Engineers Comments Regarding Surface Water Drainage

APPLICATION NO: BN/113/19/PL

Site Address: Highground Barn Highground Lane Barnham PO22 0BU

Description of Works: All-weather practice arena to support existing equestrian training
yard

Site Address:
Land North of Highground Barn
Highground Lane, Barnham.
Drawing Title:
All-Weather Surface Detail

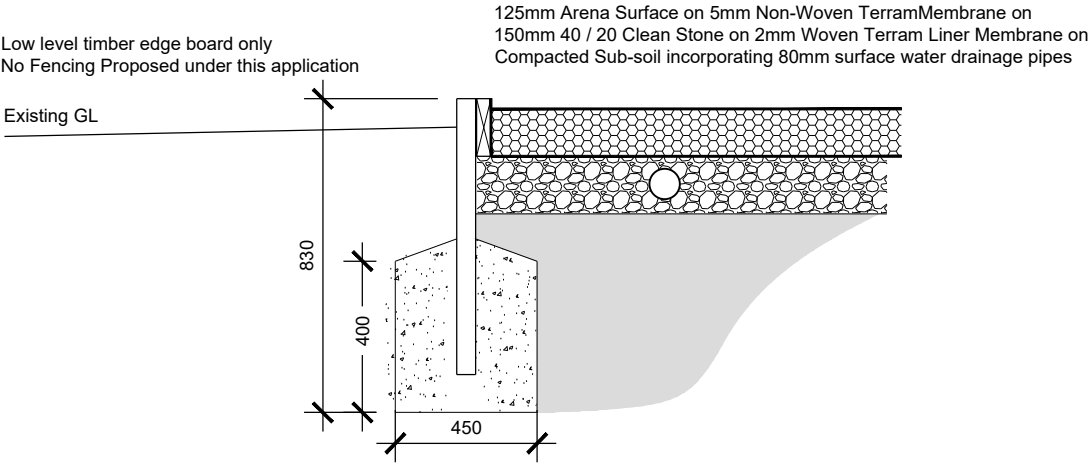
The surface design detail is noted, however no information is provided as to where the surface water drainage pipes will convey water (apart from a checkbox of soakaway on the application). The site is located within the Lidsey Treatment Catchment and in proximity to EA Flood Zones.

"Development shall not commence, other than works of site survey and investigation, until full details of the proposed surface water drainage scheme have been submitted to and approved in writing by the Local Planning Authority. The design should follow the hierarchy of preference for different types of surface water drainage disposal systems as set out in Approved Document H of the Building Regulations, and the recommendations of the SuDS Manual produced by CIRIA. Winter groundwater monitoring to establish highest annual ground water levels and winter Percolation testing to BRE 365, or similar approved, will be required to support the design of any Infiltration drainage. No building / No part of the extended building shall be occupied until the complete surface water drainage system serving the property has been implemented in accordance with the agreed details and the details so agreed shall be maintained in good working order in perpetuity."
